Appendix D

Detailed Response to Submissions

1.1 Department of Planning, Housing and Infrastructure

DPHI-1.1

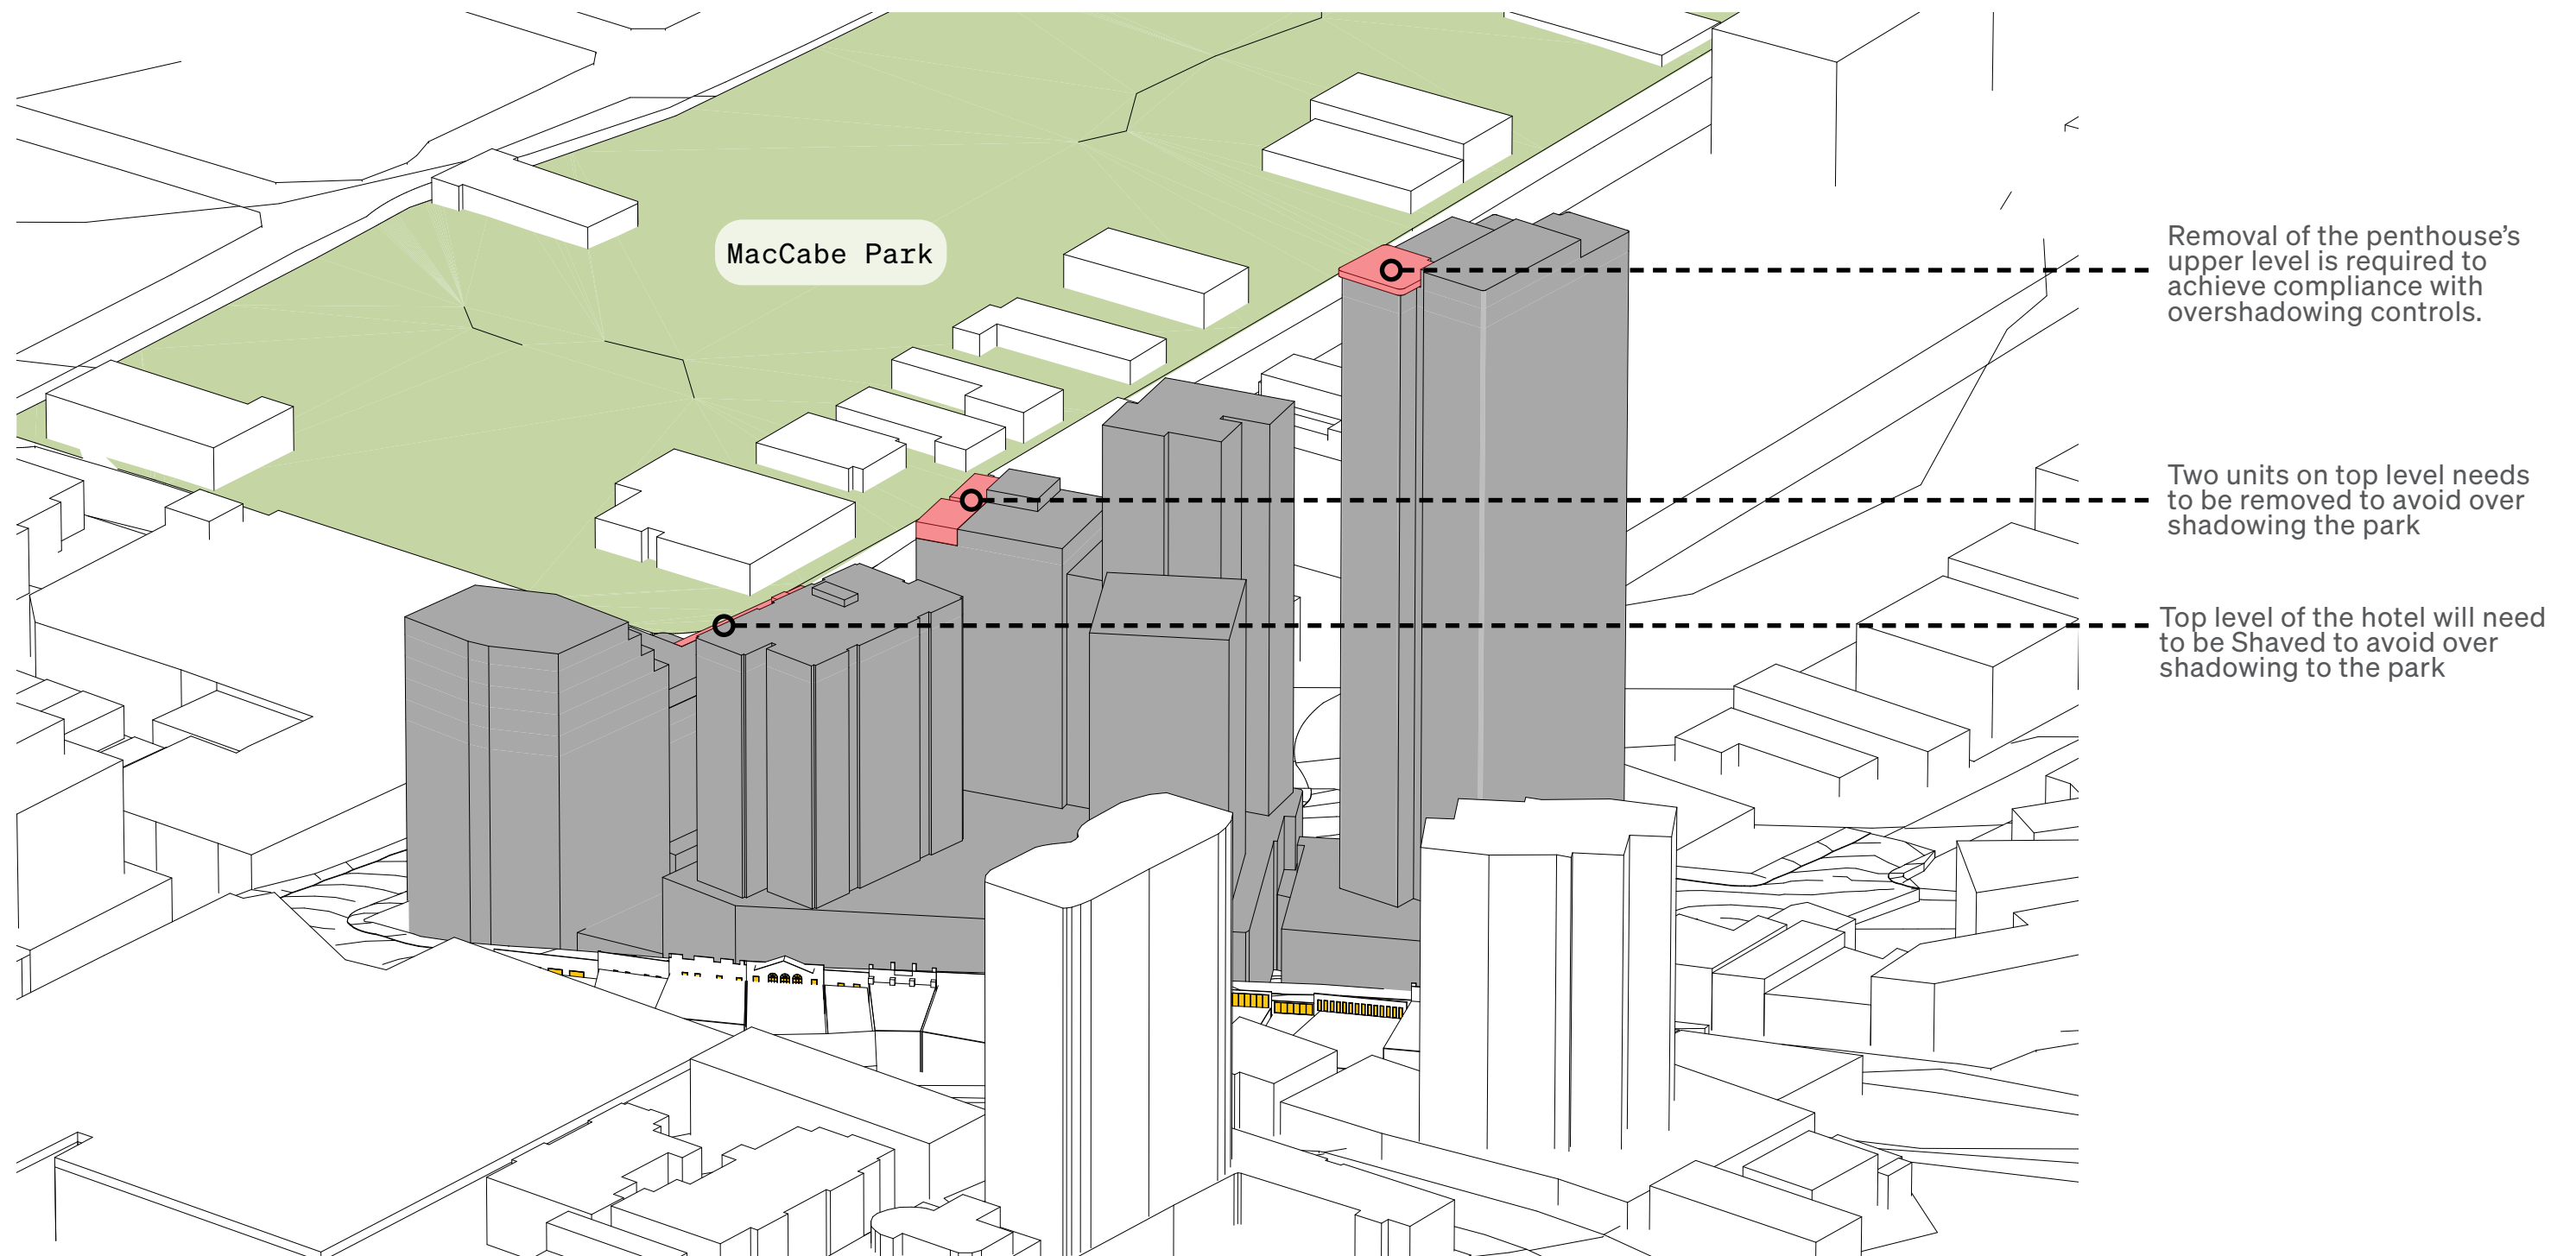
Item	Matters Raised	Responses
Submission #1		
Built Form		
DPHI-1	<i>Amend the proposed building heights to ensure the proposal complies with the sun access plane to MacCabe Park, as detailed in Clause 8.3 of the LEP, and demonstrate no overshadowing of MacCabe Park occurs between 12-2pm midwinter.</i>	The Updated Architectural Drawings at Appendix E detail the amendments to the design of the scheme to ensure no overshadowing to the sun access plane between 12pm-2pm midwinter. This includes: • reducing the height of Building 1 where it previously impacted the park; • units within Building 2.2 have been removed to reduce massing which previously overshadowed the park; and • the hotel roof level has been amended to eliminate previous overshadowing of the park. This amendment was presented to DPHI on 17 March 2026, subsequently on 18 March 2026, DPHI provided the following feedback via email: <i>"The Department supports the changes, full compliance with the sun access plane is a necessary requirement. You may re-distribute the lost GFA to other parts of the development unaffected by the plane."</i> Refer to the Architectural Design Response at Appendix I for detailed visuals that illustrate how the proposed massing has been amended to address this comment.

DA MEZZANINE LEVEL

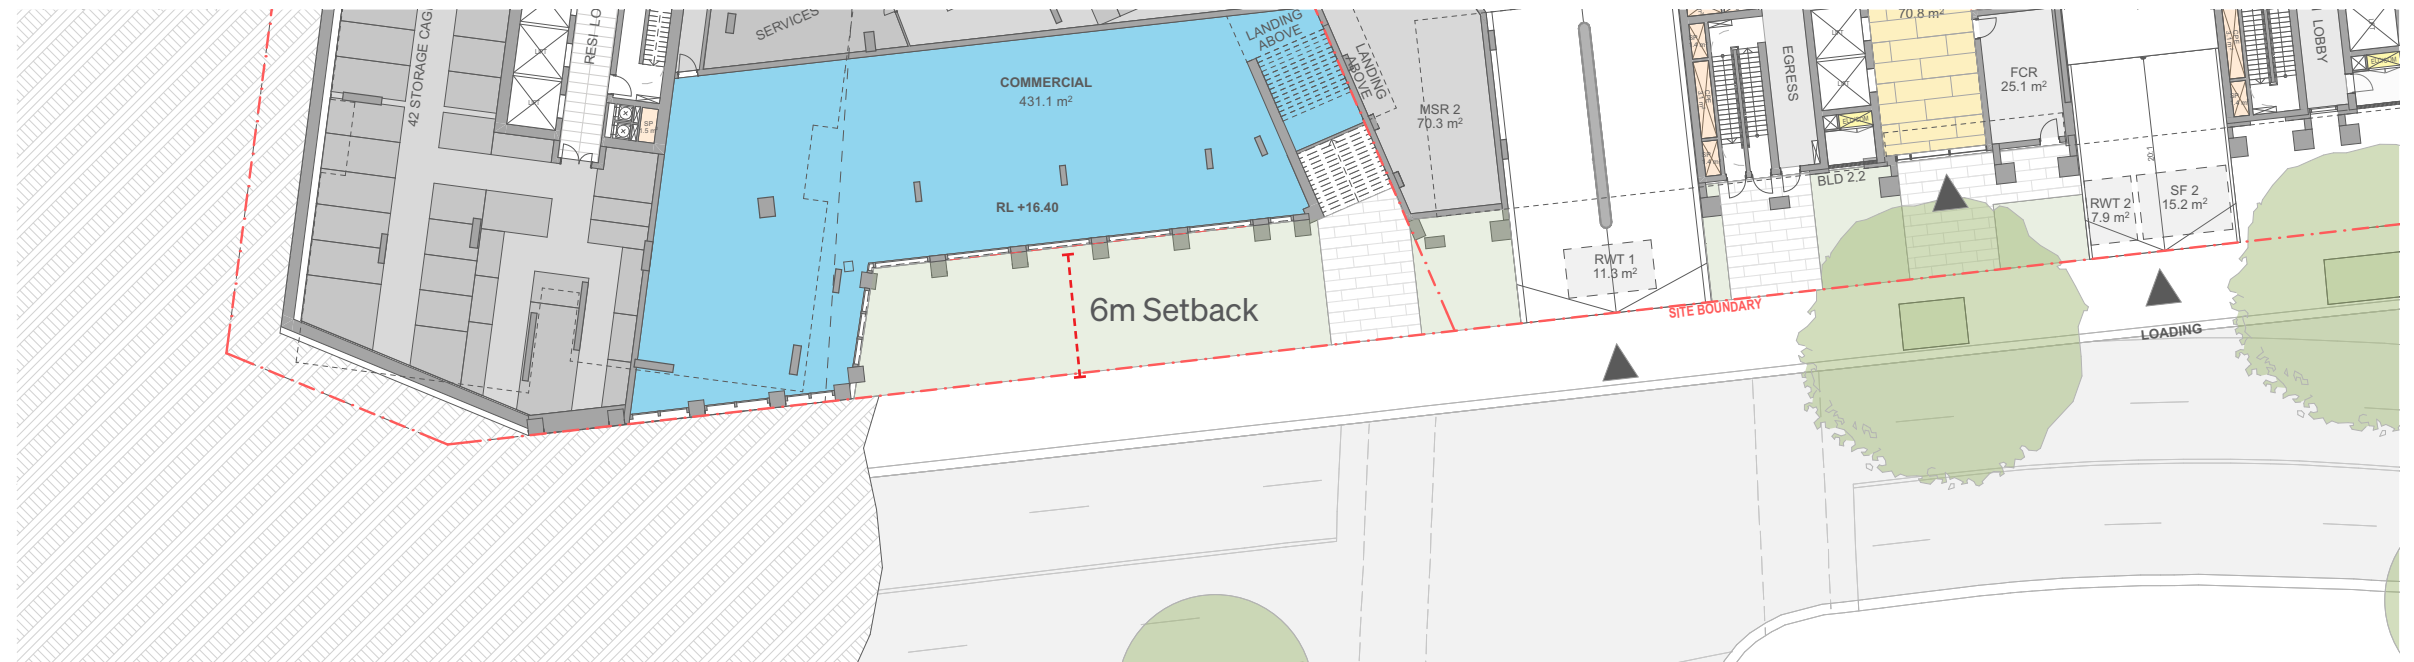
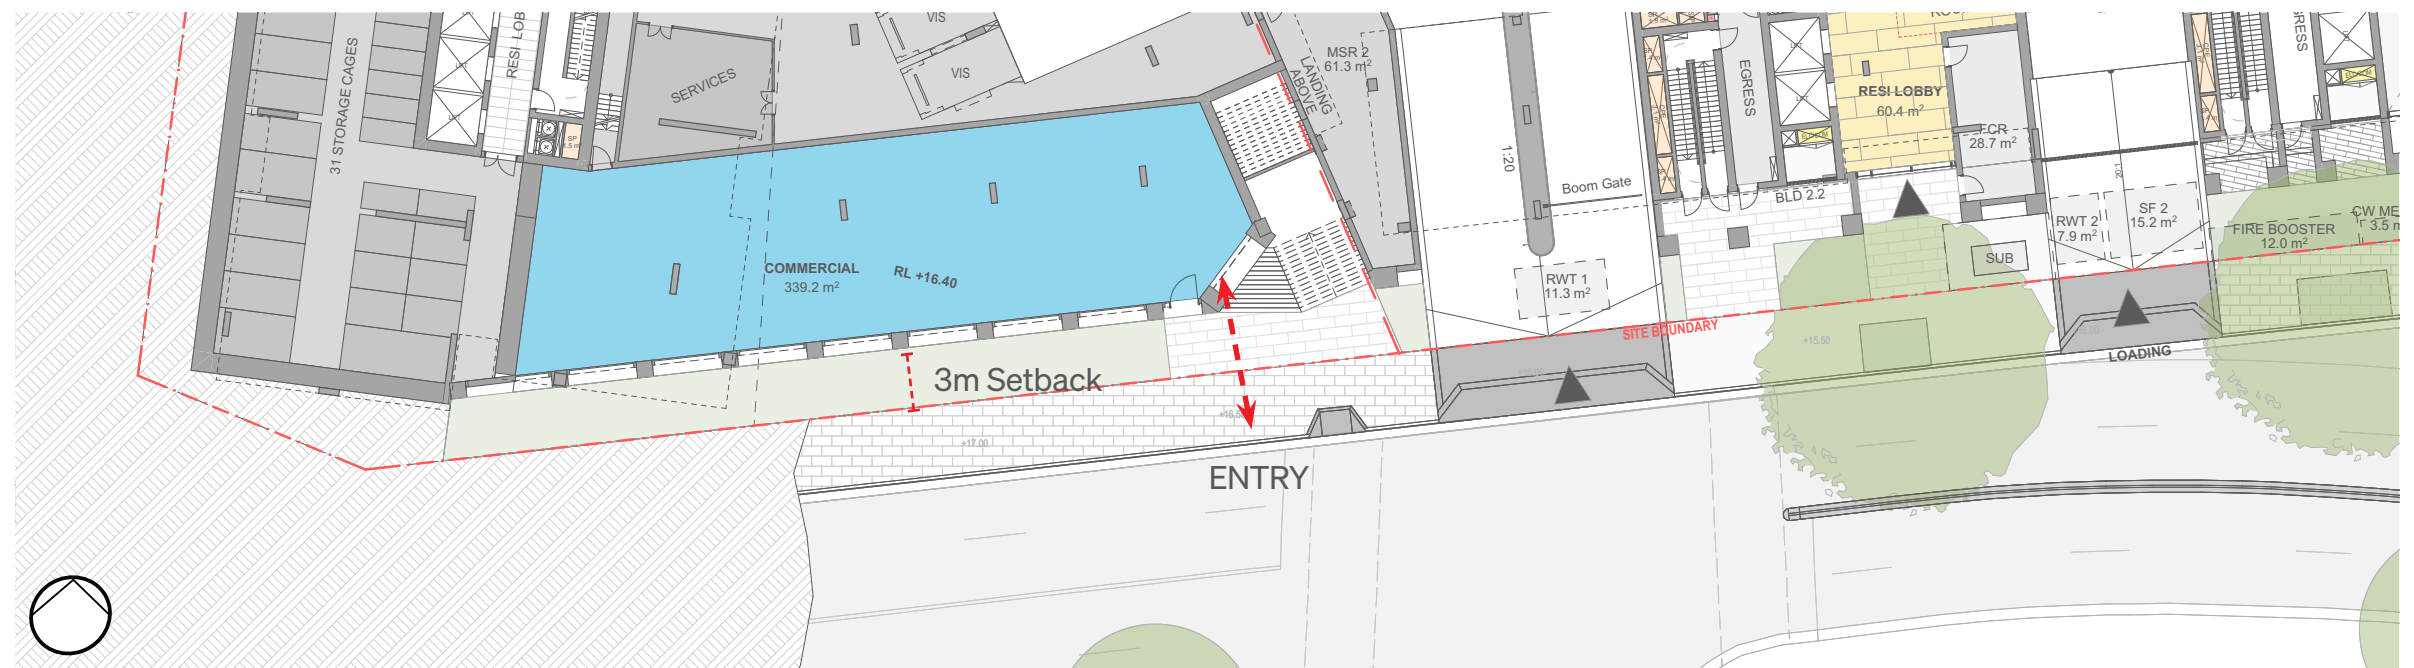
DPHI-7	<i>Improve the interface of the commercial tenancy with the street at the south-west corner of the building by improving its alignment to the street and providing an</i>	As shown in the Updated Architectural Drawings at Appendix E, the commercial tenancy line at the south-west corner of the building has been reduced to 3 metres. In addition, the landscaping in front of the commercial tenancy has been redesigned as a more civic-style landscape treatment to improve clear sightlines and provide level, accessible entry

Item	Matters Raised	Responses
	<i>accessible, street-level entry. Ensure any landscaping in front of the tenancy maintains clear sightlines to the street.</i>	to the tenancy. The revised commercial tenancy design also provides a distinct separate interface with the Marcus Clark façade, and proposed greater retention of the façade fronting Burrelli Street. This amendment was presented to DPHI on 17 March 2026, subsequently on 18 March 2026, DPHI provided the following feedback via email: <i>“The Department’s key concern was that the tenancy appeared to be sunken from street level (due to the provided public domain RLs). The new renders show street level entry which is supported. Ensure accurate levels are provided in the RtS plans. Further design development is recommended to ensure a proper interface is maintained between the Marcus Clarke building and Building 01 on the Burrelli street setback, the changes must be supportable from a heritage perspective, with updated documentation provided.”</i>

AMENDED LOWER GROUND PLAN

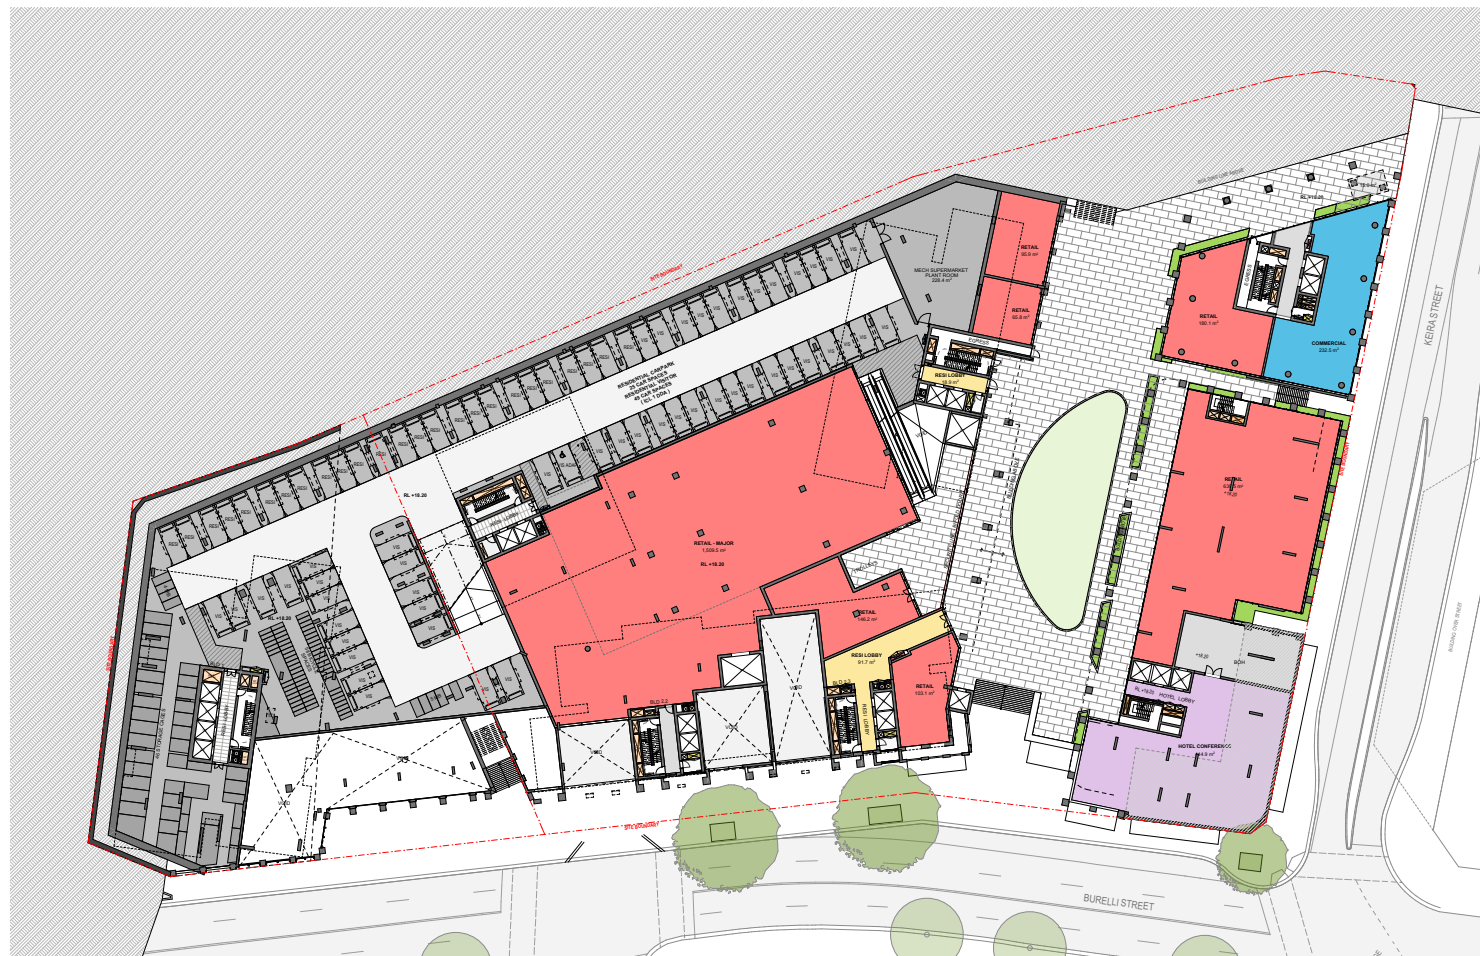
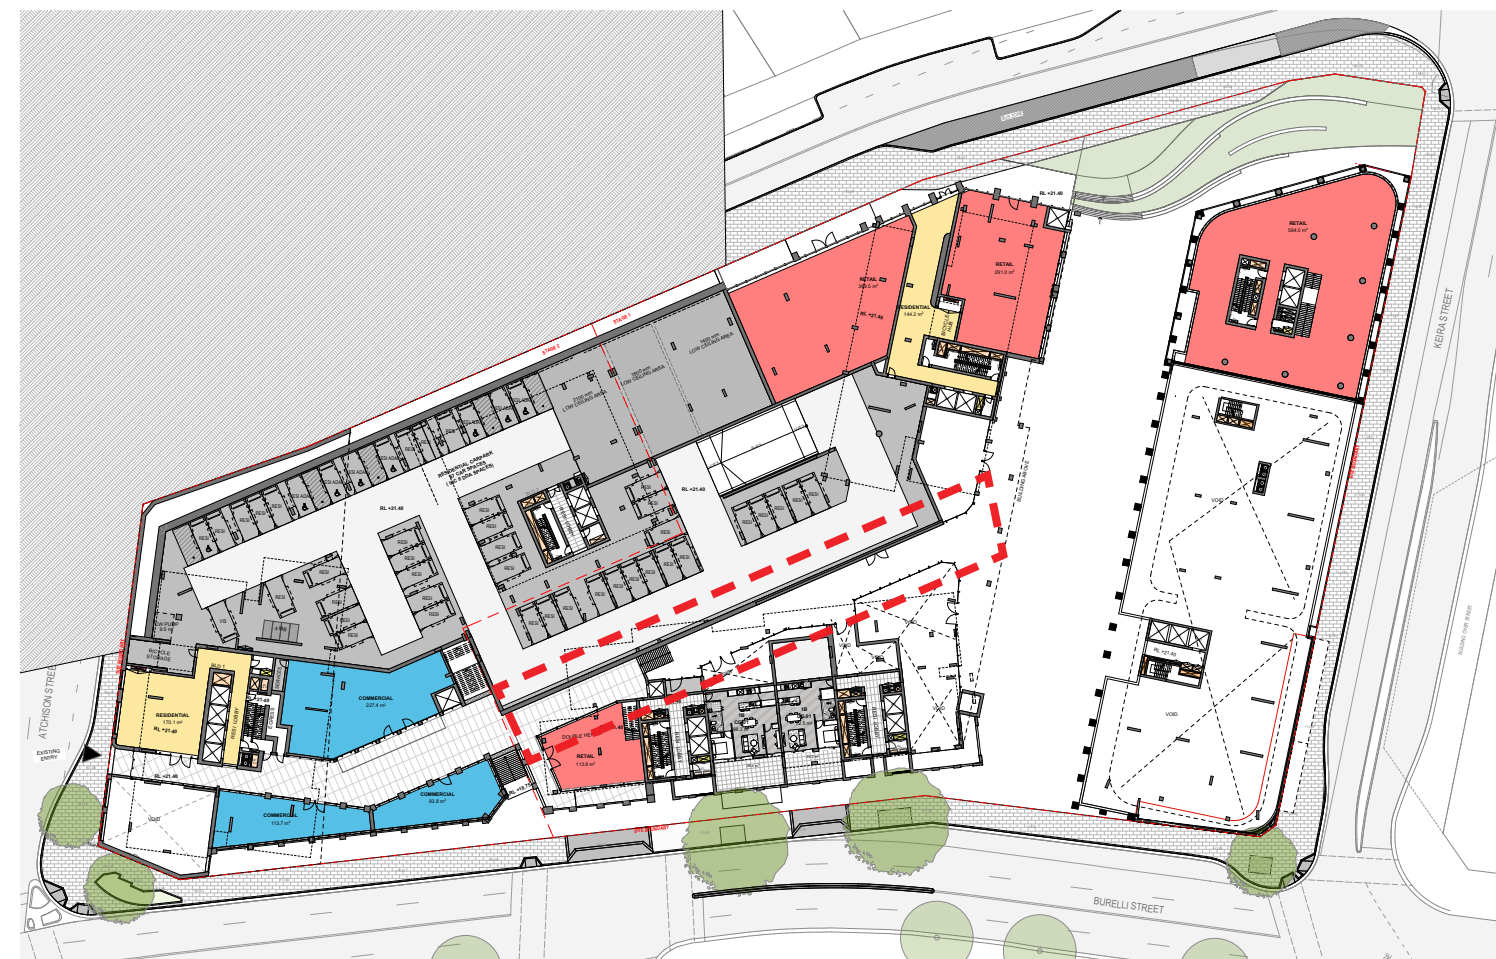
Pedestrian Permeability		
DPHI-12	<i>Consider options to enhance east-west permeability through the podium by providing a connection/additional entry from the supermarket to the western through-site link, as well as a connection from the Marcus Clarke building's large retail tenancy to both the western laneway and Atchison Street.</i>	In response to this recommendation by DPHI, the Applicant has revised the design of the scheme to include the provision of an east to west pedestrian through-site link. The proposed new through-site link will connect from the proposed eastern public plaza at lower ground floor to the western laneway at ground floor. The new through-site link will include frontage and access to retail tenancies at the eastern end of the site and residential lobbies to Building 2.3, ensuring the link will be activated and benefit from good levels of pedestrian and resident footfall. The proposed through-site link will be 4.5 m wide along its entirety, with a double-height clearance of 6m from the plaza level and 3m from the laneway level. To ensure safe access and movement through the site in accordance with CPTED principles, the through-site link will be gated and closed outside of normal business hours (8am – 6pm). Refer to the Lower Ground Floor (DA2003) and Ground Floor (DA2004) of the Updated Architectural Drawings at Appendix E and the Updated Design Report at Appendix F. It is noted that the proposed development no longer includes a supermarket tenancy.
